CITY OF ALBUQUERQUE

PLANNING DEPARTMENT – Development Review Services

July 10, 2014

RE: Warehouse Addition -2655 Baylor Drive SE
Grading & Drainage Plan
Engineer's Stamp Date 6-30-2014 (File: M16D006)

DRAINAGE PLAN

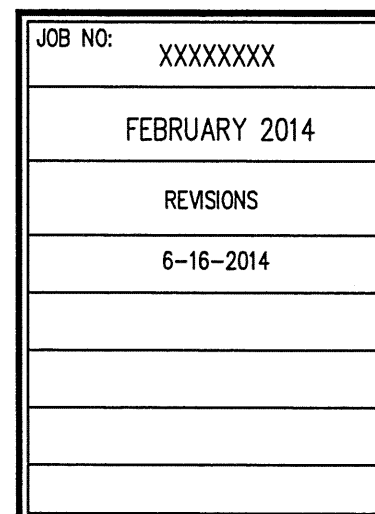
- 1) Revise drainage calculations to show that the difference between the Proposed Peak Flow and the Pump Rate is less than or equal to the Existing Peak Flow ($Q_{\text{proposed}} - Q_{\text{pump}} \leq Q_{\text{existing}}$), and show on plans that this Flow will first fill the shallow pond before it spills onto property to the west, as it historically has drained.

- 2) A new contour (about 58.5') will show that water overflowing the top of pond will flow to the west and spill over the wall (Top of Wall Elev at 58.2') in sheetflow rather than a spillway. Show the FG Elevation around proposed building will be lower than 58.2' (the Top of Wall and Top of Pond). Show spot elevations on all sides around building.

- 3) Show spot elevations south of existing building and at beginning of concrete trough/swale to show that flows will be directed west before they overflow north.

- 4) As discussed, the Top of Pond Elevation will remain at 58.2' but is not the 100 year WSEL. Using a hydrograph determine if the pond volume can hold the 10 yr storm and show in calculations. (ie. $V_{10\text{yr}} > V_{\text{pond}}$)

- 5) On the hydrograph, account for the pump rate.
- 6) Spot elevations on north end of pond need to be noted as existing elevations.
- 7) Eliminate opening in retaining wall on south side of property to prevent flow out of property.

- 8) Remove High point on SE corner of proposed building so that overflow of pond is directed west, as noted above.
- 9) The SO-19 notes need to be on the first sheet and clearly visible.

1. Revise drainage calculations to show that the difference between the Proposed Peak Flow and the PUMP rate is less than or equal to the Existing Peak Flow ($Q_{\text{proposed}} - Q_{\text{pump}}$) is less than or equal to Q_{existing}) and show on the plan that this flow will first fill the shallow pond before it spills onto property to the west, as it historically has drained. *The plan drawing has been revised to show that the proposed flows minus the pipe flow equals the historical flows. The plan drawing has been revised with new spot elevations to indicate the developed flows will first fill the shallow pond before overflowing to the west.*

2. A new contour (about 58.5') will show that water overflowing the top of pond will flow to the west and spill over the wall (Top of Wall Elev. At 58.5') in sheet flow rather than a spillway. Show the FG Elevation around proposed building will be lower than 58.2' (Top of Wall and Top of Pond). Show spot elevations on all sides around building. *A new contour (58.5') has been added to the plan drawing. Finish spot elevations have been added to the plan drawing showing a spot elevations lower than 58.2'.*

3. Show spot elevations south of existing building and at beginning of concrete trough/swale to show that flows will be directed west before they overflow north. *New spot elevations have been added to the plan drawing to indicate that no developed flows will spill over to the north and within the existing valley gutter.*

4. As discussed, the Top of Pond Elevation will remain at 58.2' but not the 100-year WSEL. Using a hydrograph determine if the pond volume can hold the 10 year storm and in calculations. (ie. $V_{10\text{-year}} > V_{\text{pond}}$). *A hydrograph has been included on the plan drawing for the 10-year storm. The calculations have been included on the plan drawing showing that the proposed pond volume is greater than the 100-year 10-year storm.*

5. On the hydrograph, account for the pump rate. *The pump rate has been included on all the calculations.*
6. Spot elevations on north end of pond need to be noted as existing elevations. *Plan drawing has been revised to indicate the existing spot elevations.*

7. Eliminate opening in retaining wall on south side of property to prevent flow out of property. *Wall has been extended east and tied onto the retaining wall coming from the west.*

8. Remove High Point on SE corner of proposed building so that overflow of pond is directed west, as noted above. *Notation High Point has been removed from the plan drawing and new spot elevation have been included to indicate the flows will be routed west.*

9. The SO 19 notes need to be on the first sheet and clearly visible. *Notes and sign-off block has been inserted on the first sheet of the plan drawing.*
10. Clearly indicate on the pump cut sheets what pump is selected and which line to follow on the line graph. *Pump cut sheets have been marked to identify pump to be used along with depth and rate.*

SUMP WITH PUMP DETAIL

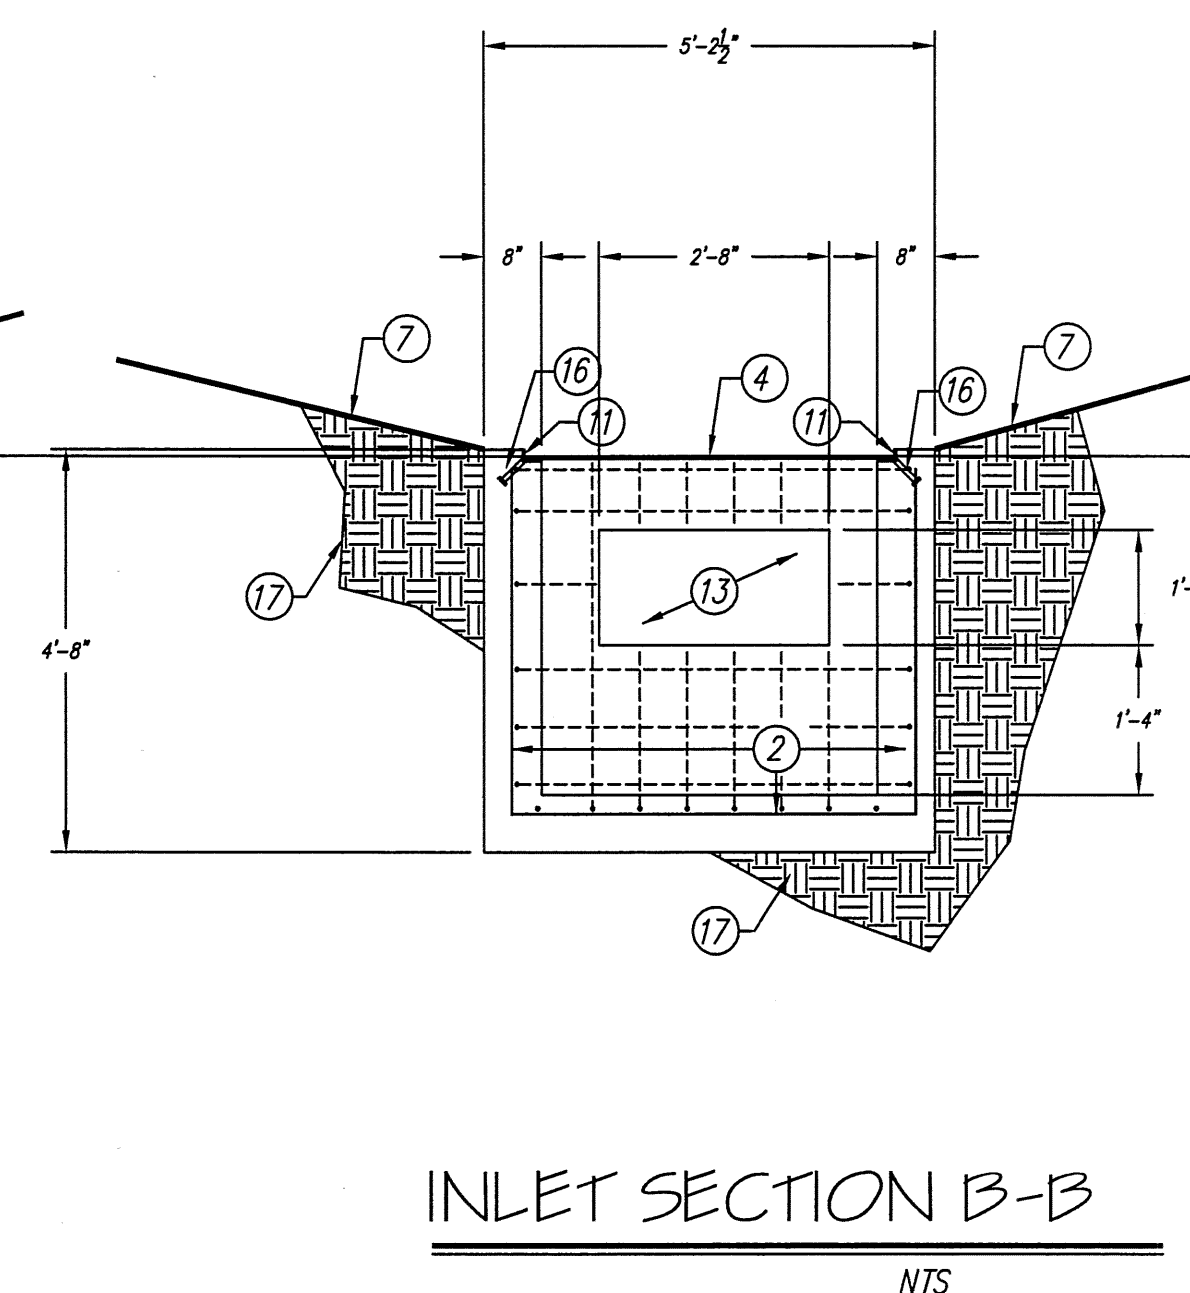
- 10) Clearly indicate on the pump cut sheets what pump is selected and which line to follow on the line graph.
